**Section 106 Town and Country Planning Act 1990**  
**Application for Approval of Details to Satisfy an Obligation**

Application for revised approval of the open space scheme as required under the second schedule, clause 1(a) of the section 106 dated 30-10-20 linked to Outline planning permission AL/21/20/OUT (previously approved under AL/97/23/AOO (in part) and AL/166/23/AOO).

Land North of Lee's Yard Lidsey Road Woodgate PO20 3SU

Ordering No. CSA/5742/100	Rev
---------------------------	-----

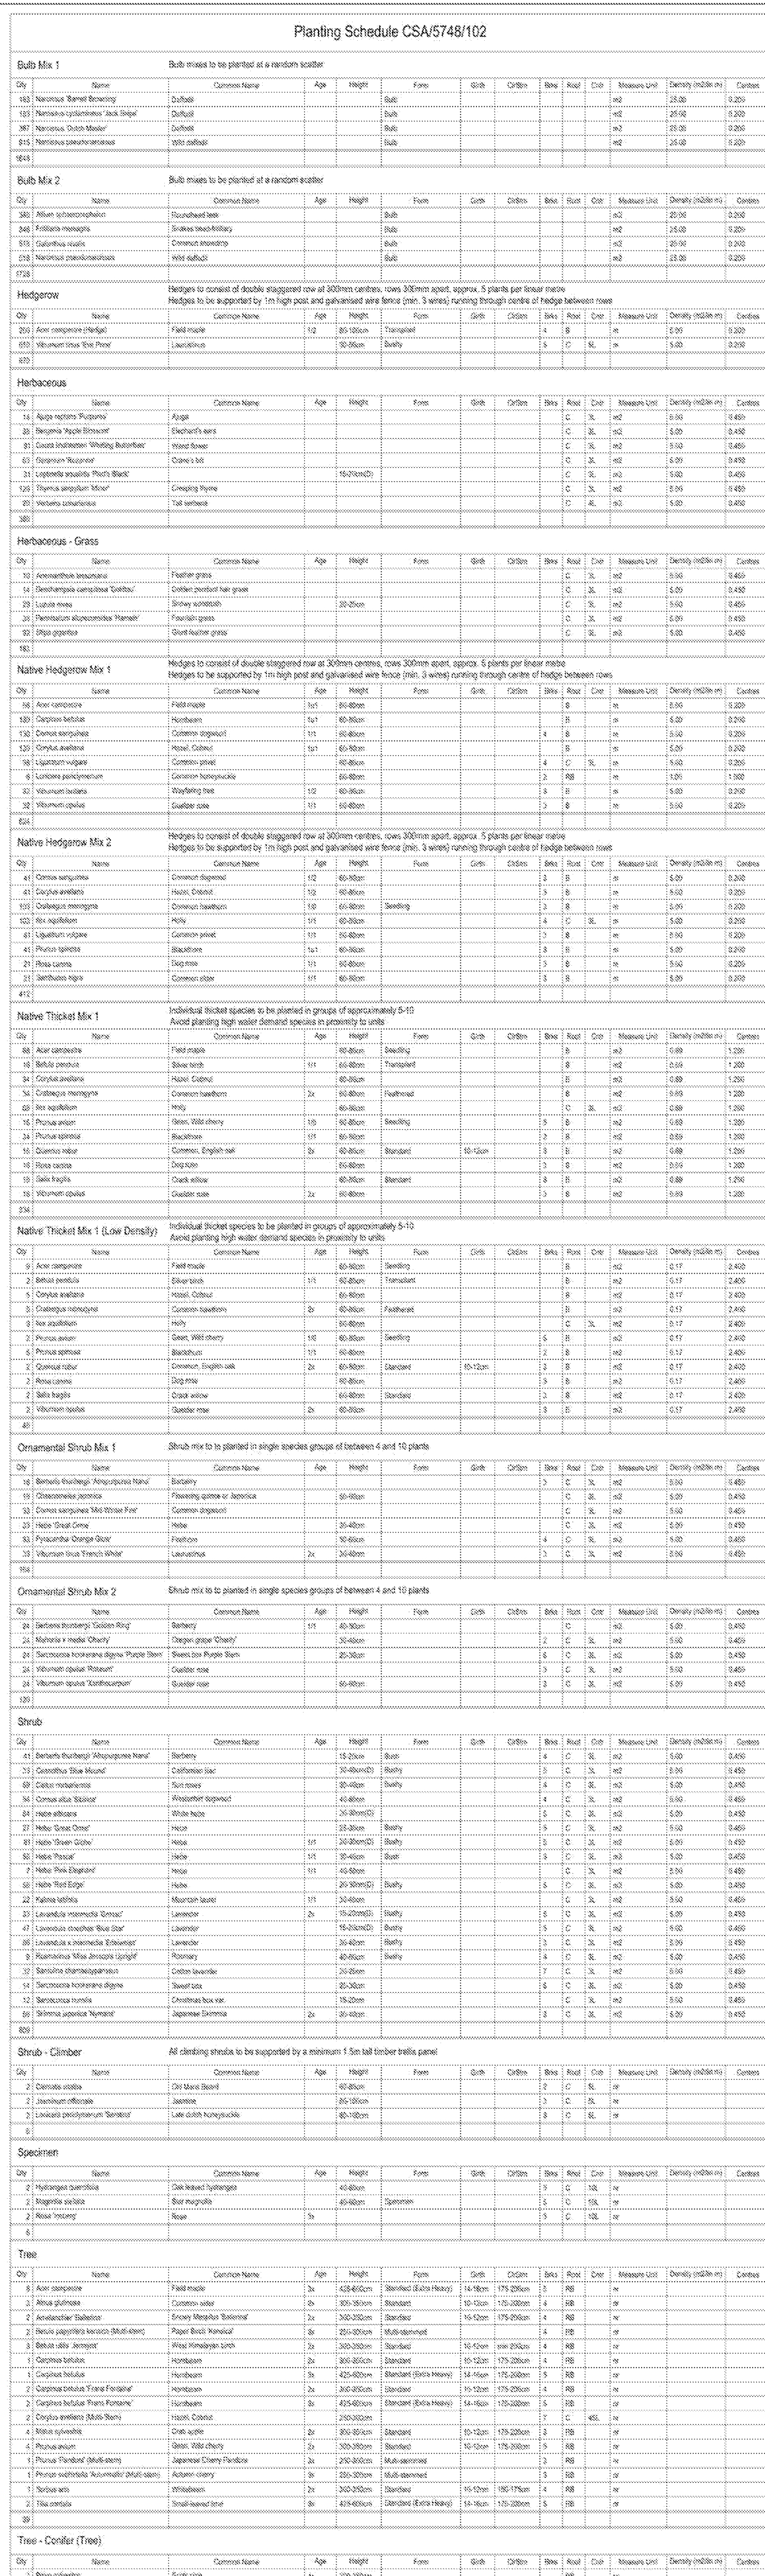
You now propose an alteration to the Public Open Space scheme comprising the replacement of the previously proposed "Community Growing Area" with a grassed amenity space. The change also requires an amendment to the associated management arrangements. The change is due to the Parish Council no longer wishing to take on the community growing space. The following amended documents have been submitted:

It is noted that the layout of the particular area will not be materially altered as it remains a 'green' area enclosed by a hedge although a bench is now proposed in place of a shed; rather it is the use of the space that will change from the growing of plants to general amenity. The Councils Landscape Officer raises no concerns with the changes.

The information has been reviewed by Simon Davis MRTPI (Principal Planning Officer of Arun District Council) and meets the requirements of paragraph 1(a) and (b) of the third schedule to submit the Open Space Scheme to the Council for approval.
